Submissions Report
New High School in Jerrabomberra
SSD-24461956

On behalf of
NSW Department of Education
March 2022

This Submissions Report has been prepared by Mecone NSW Pty Limited on behalf of the NSW Department of Education to support the proposed new high school in Jerrabomberra (SSD-24461956).

Appendix E – Pedestrian Traffic Safety Fence Location and Type Drawings

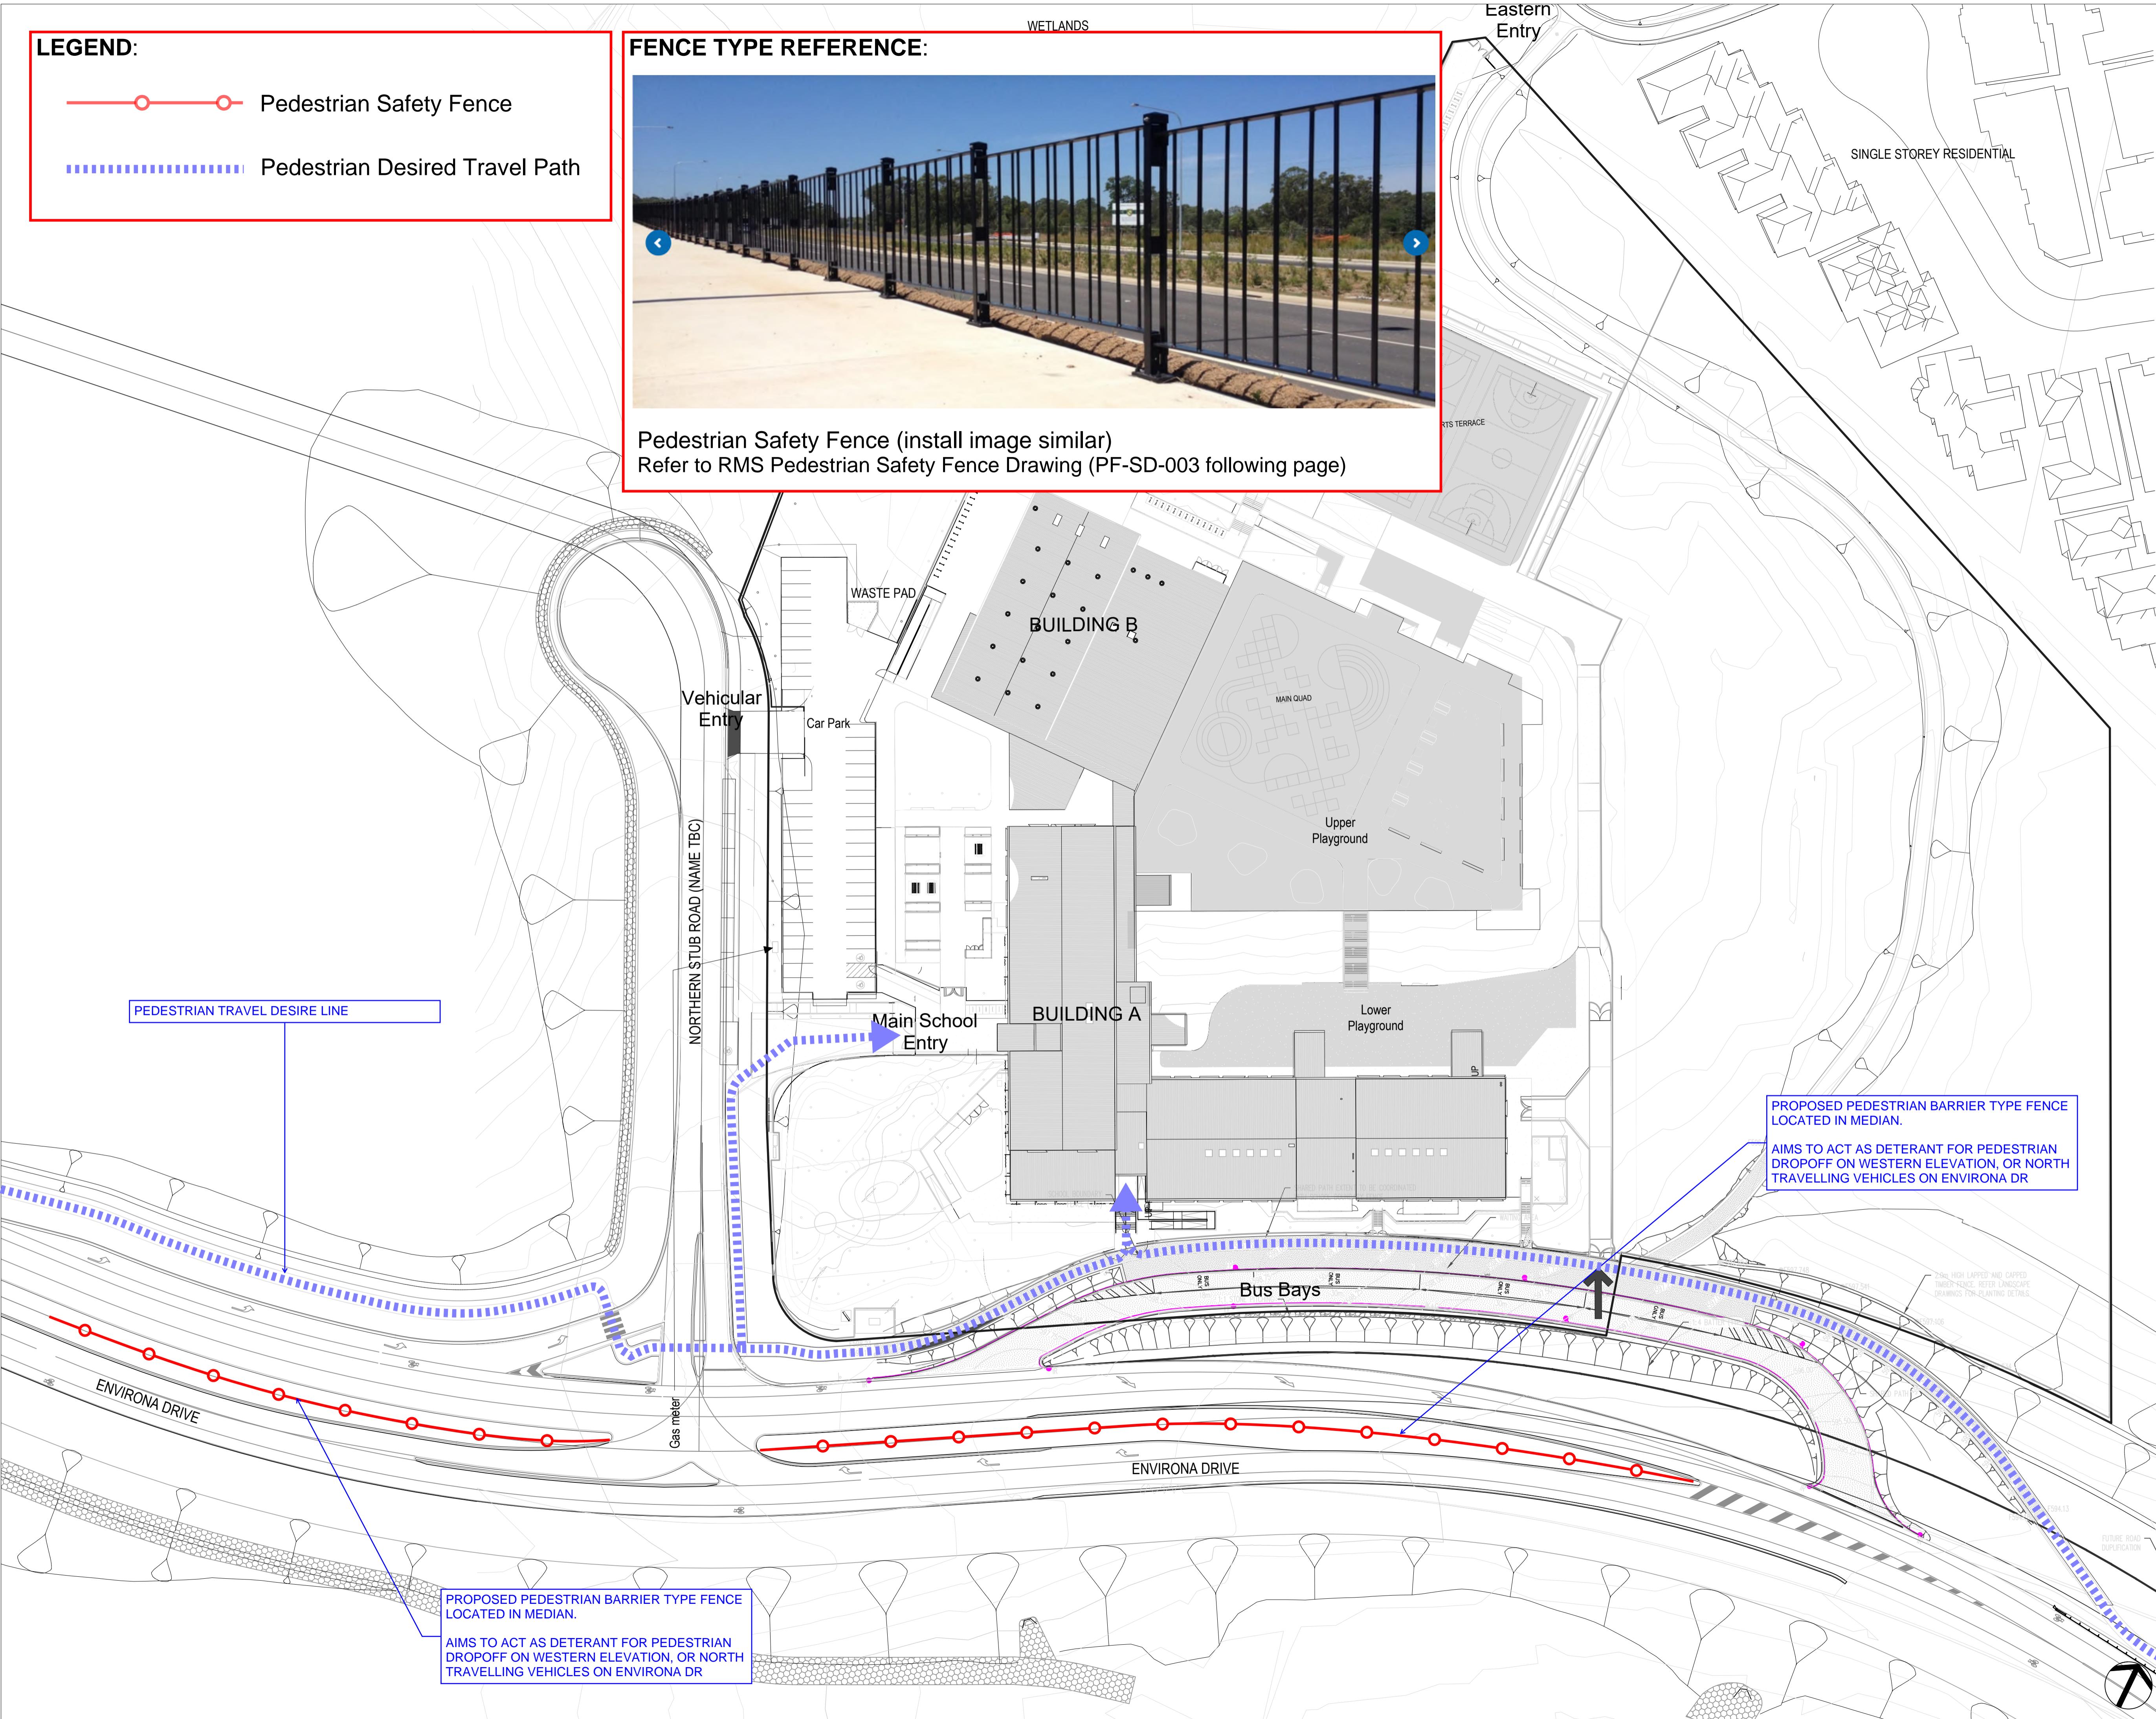
<p>8. Crossings and Pedestrian Movements</p> <p>Council considers that one mid-block crossing on the north road, away from the intersection where vehicles are turning and drivers are making turning movement decisions, would provide a better safety outcome for pedestrians. Council also considers that the Transport Assessment contains insufficient information on how pedestrian movement from the western side of Environa Drive will be discouraged.</p> <p>Recommendations:</p> <ul style="list-style-type: none"> That the applicant be requested to revisit the need and proposed location for a school crossing adjacent to the main school entry off the north road. (Objection) That the applicant be requested to provide further information on how the movement of pedestrian from the western side of Environa Drive can be discouraged. (Objection) 	<p>GHD has revisited the potential for a mid-block crossing on the northern road and has found that the No Stopping signage required for the crossing is inconsistent with the road's geometry or the kiss-and-drop operations. Therefore, the mid-block crossing is not considered feasible, and the crossing will remain at the intersection of the stub road and Environa Drive as originally proposed. Refer to GHD's letter at Appendix 5 for further discussion.</p> <p>Regarding pedestrian movements from the western side of Environa Drive, No Stopping signage and fencing will be installed to discourage such movement. Refer to GHD's letter at Appendix 5 for further detail.</p>

REVISED DESIGN

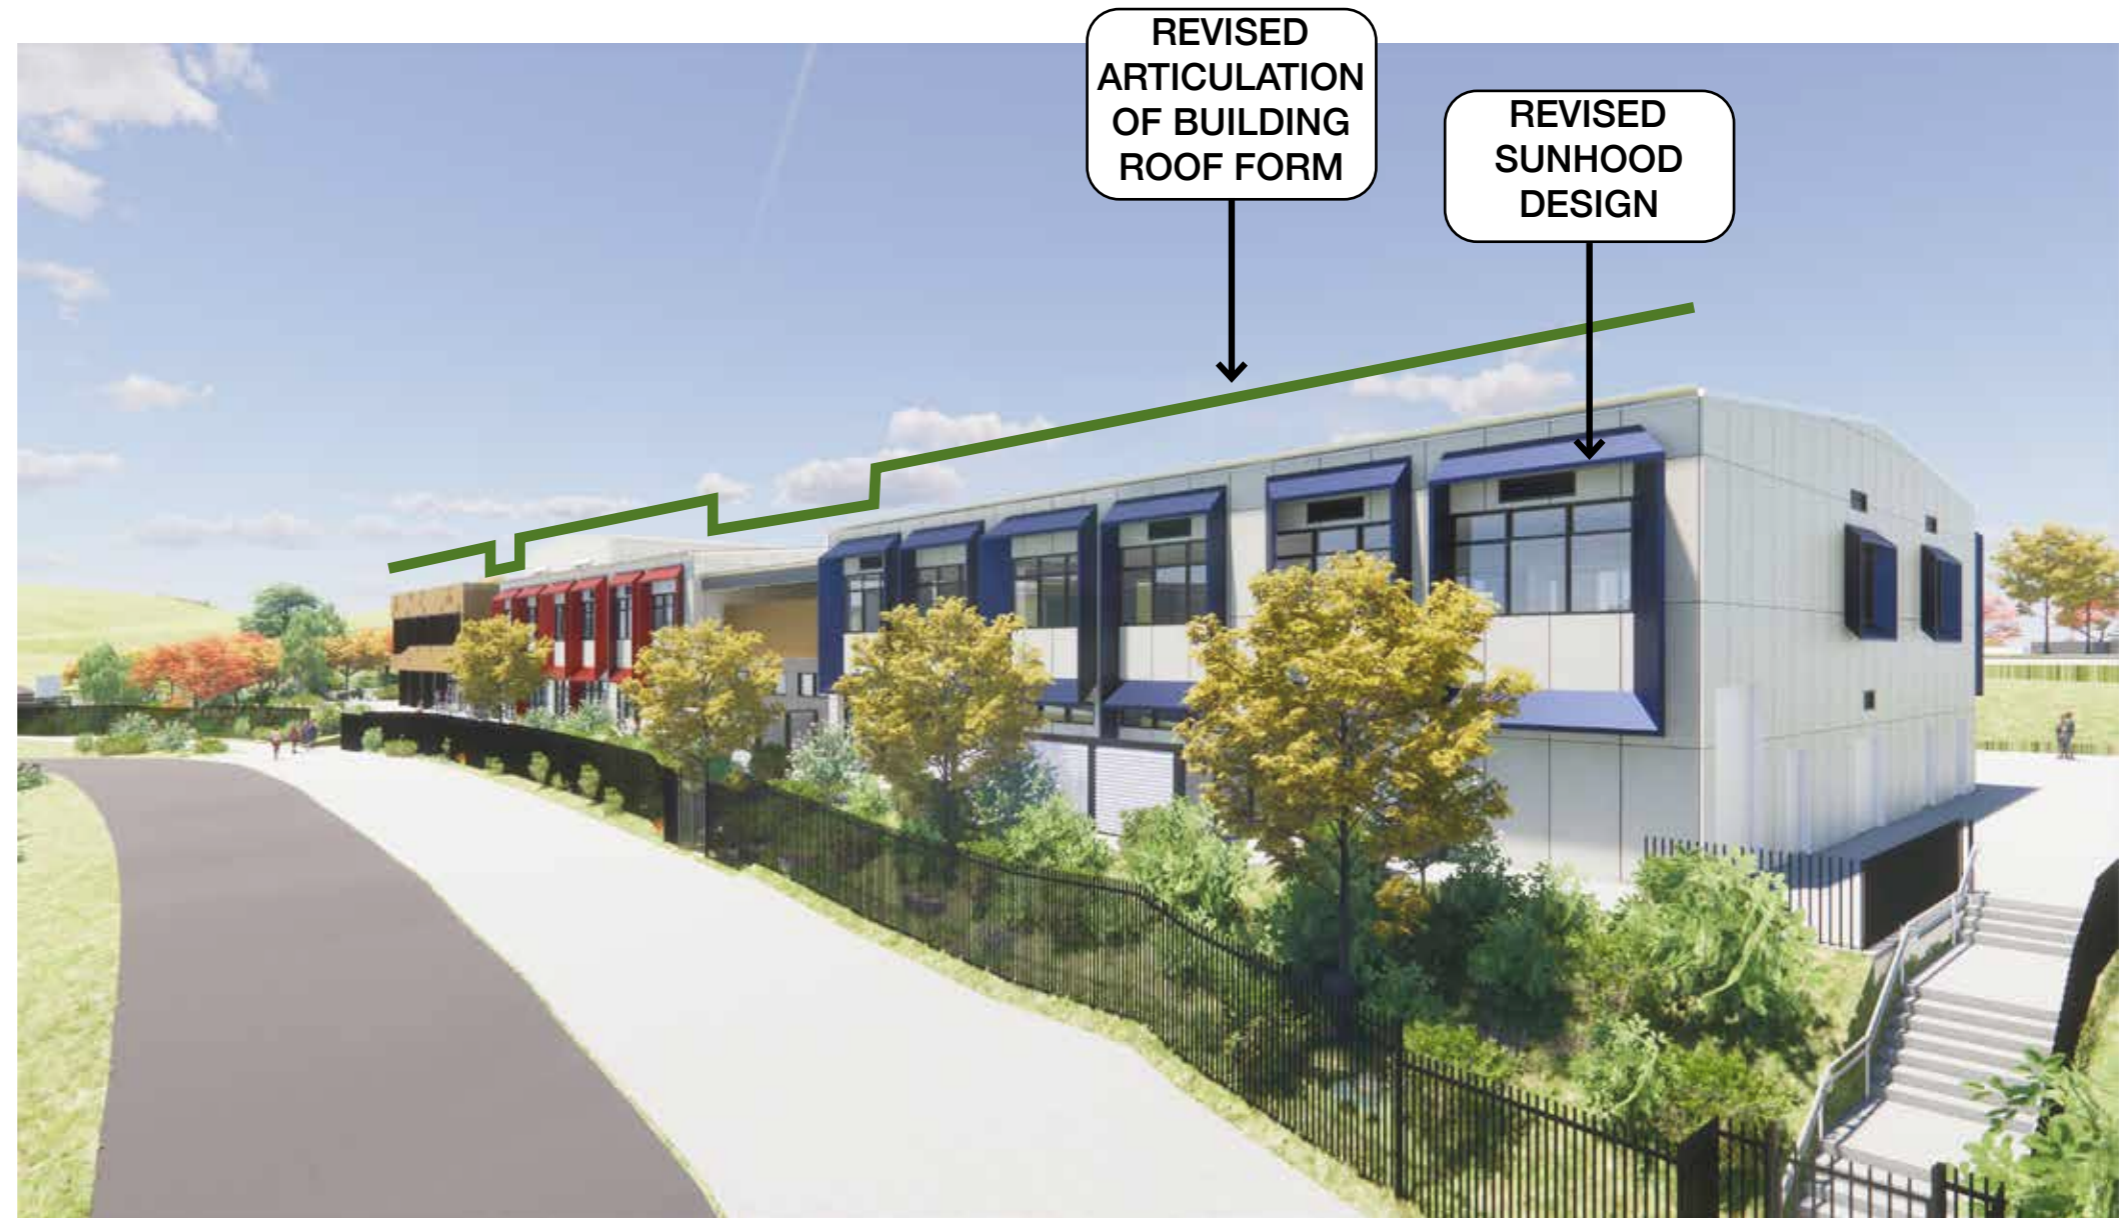
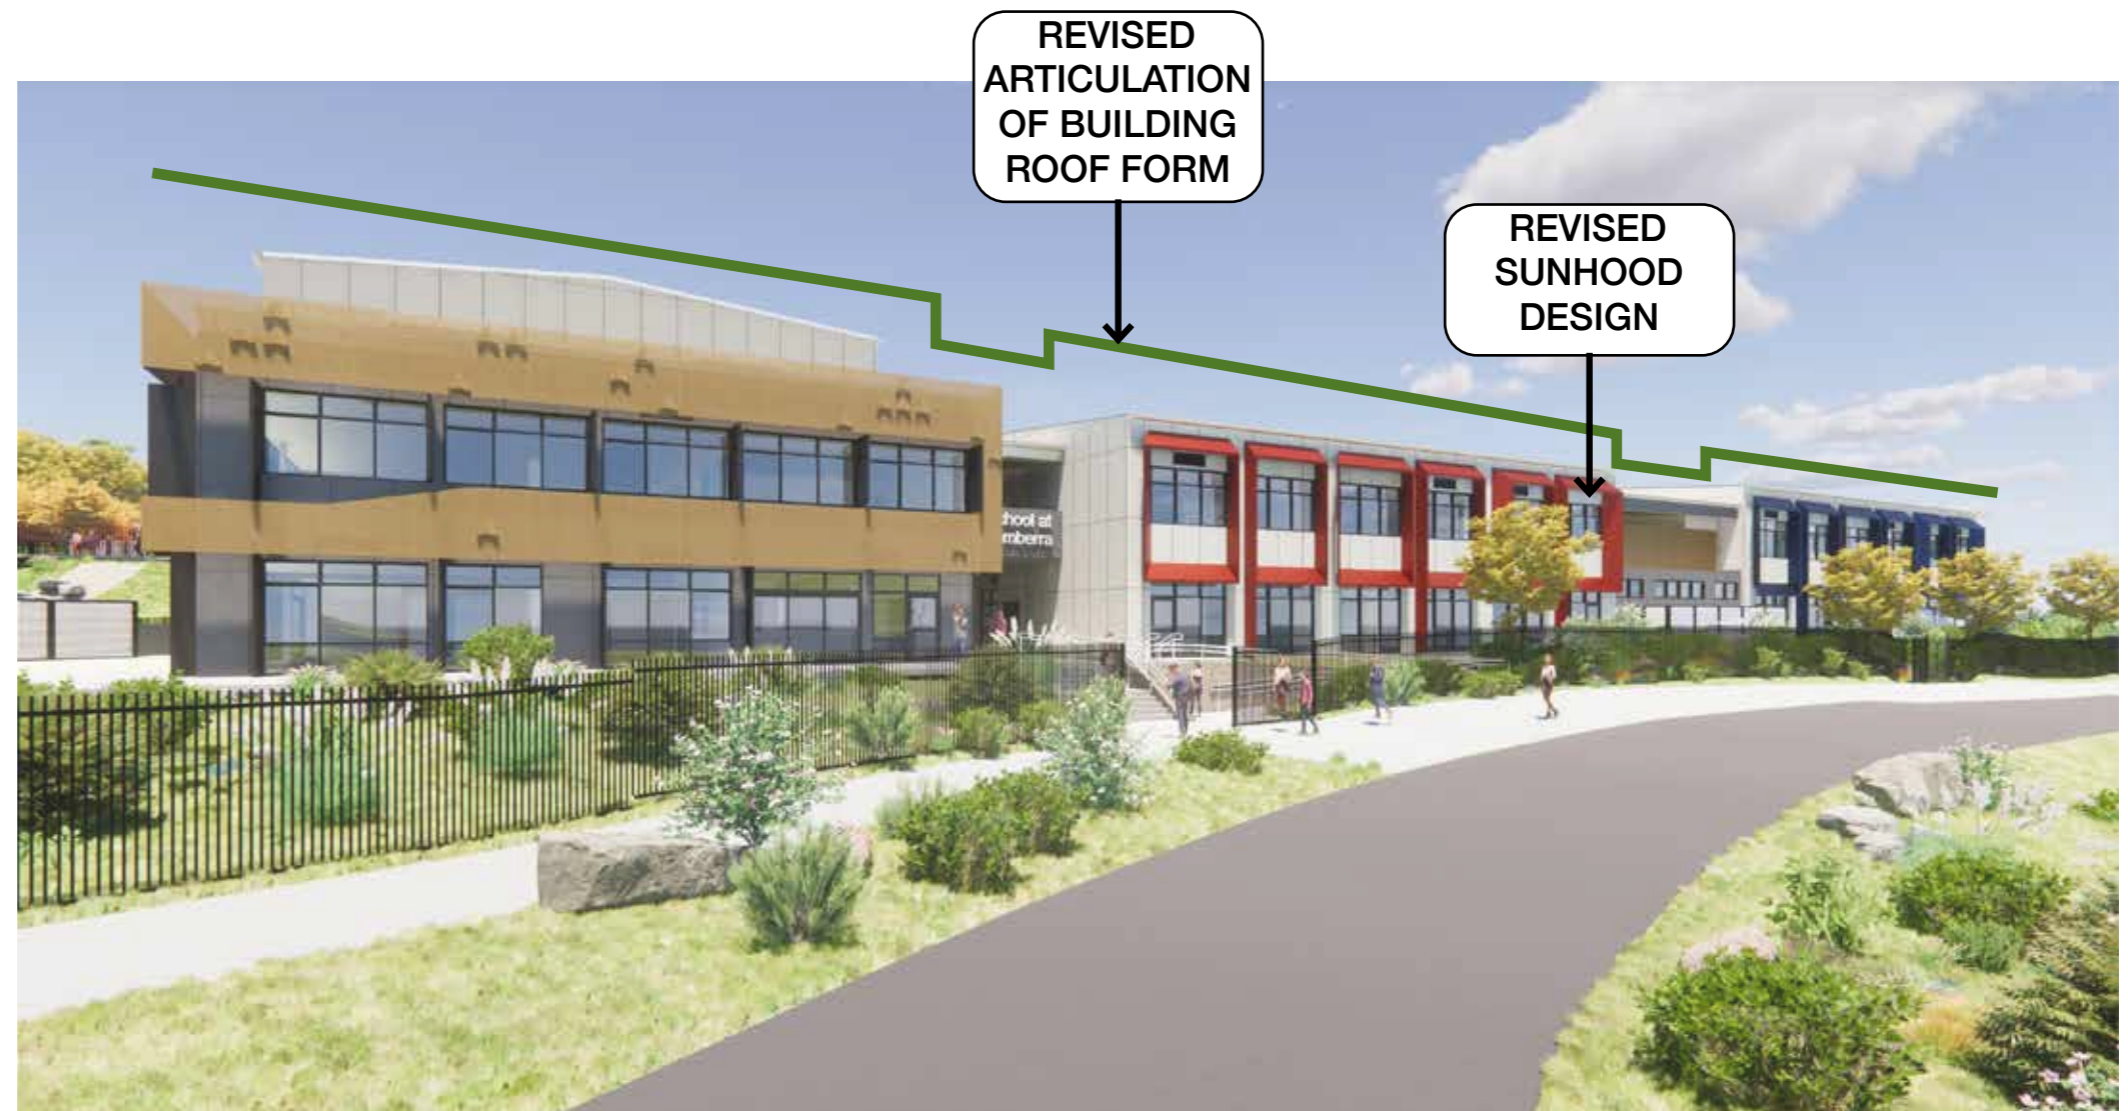
Key issue	Response
2. Design and Built Form	
<p>The Government Architect NSW has advised that the proposal has not adequately addressed a number of matters raised in the State Design Review Panel (SDRP) advice dated 15 July 2021.</p> <p>The following recommendations of the SDRP advice must be addressed:</p> <ul style="list-style-type: none"> • Recommendation 7c – the response does not include any options testing, and the recommendation to explore how the connection between the David Madew Oval and the school is connected and inclusive has not been adequately addressed. Options to provide an inclusive and equitable connection between the Oval and the school must be explored. 	<p>The connection to the David Madew Oval has been addressed within the constraints presented by the topography of the site. A series of ramps compliant with the enhanced requirements of AS 1428.2-1992 have been provided adjacent to the steps, ensuring that all users have choice to address the level change in the way most appropriate to their needs or disability. The ramps meet the EFSG requirement to provide landings at 6m intervals (in lieu of 9m intervals as per the requirements of the BCA) to ensure the route is suitable for students or users who might tire more easily. Rest points with seating are incorporated at a maximum of 50m intervals along the ramped route, to allow an opportunity for students and staff to rest and recover, extending the ability to comfortably travel longer distances. Refer to TKD's response at Appendix 7 for further discussion.</p>

<p>The school campus has been designed to allow for optimum accessibility with consideration of the site contours.</p> <p>The lift and adjacent main stair, which are centrally located and connect all levels of the school, are located in close proximity to the social plaza and creative play space, providing a legible, pragmatic circulation route.</p> <p>To transition the steep level change between the Creative Play space and Social Plaza would require a large network of ramps, removing a significant portion of the central courtyards green space. This option, therefore, was deemed detrimental to the quality of the external space.</p> <p>An alternative accessible route from the Social Plaza to the Creative Play is provided to the south of the plaza in the event the lift is unable to be used.</p>
<ul style="list-style-type: none"> • Recommendations 11 and 12a – opportunities must be pursued to articulate the volume of Building A along Environa Drive to reduce the visual bulk and allow for more opportunities for natural ventilation. 	<p>Building A has been further articulated to reduce visual bulk and allow for more natural ventilation. This has been achieved through breaks in the building form and revisions to the fenestration. Refer to TKD's response at Appendix 7 for further detail and also the description in Table 1.</p>
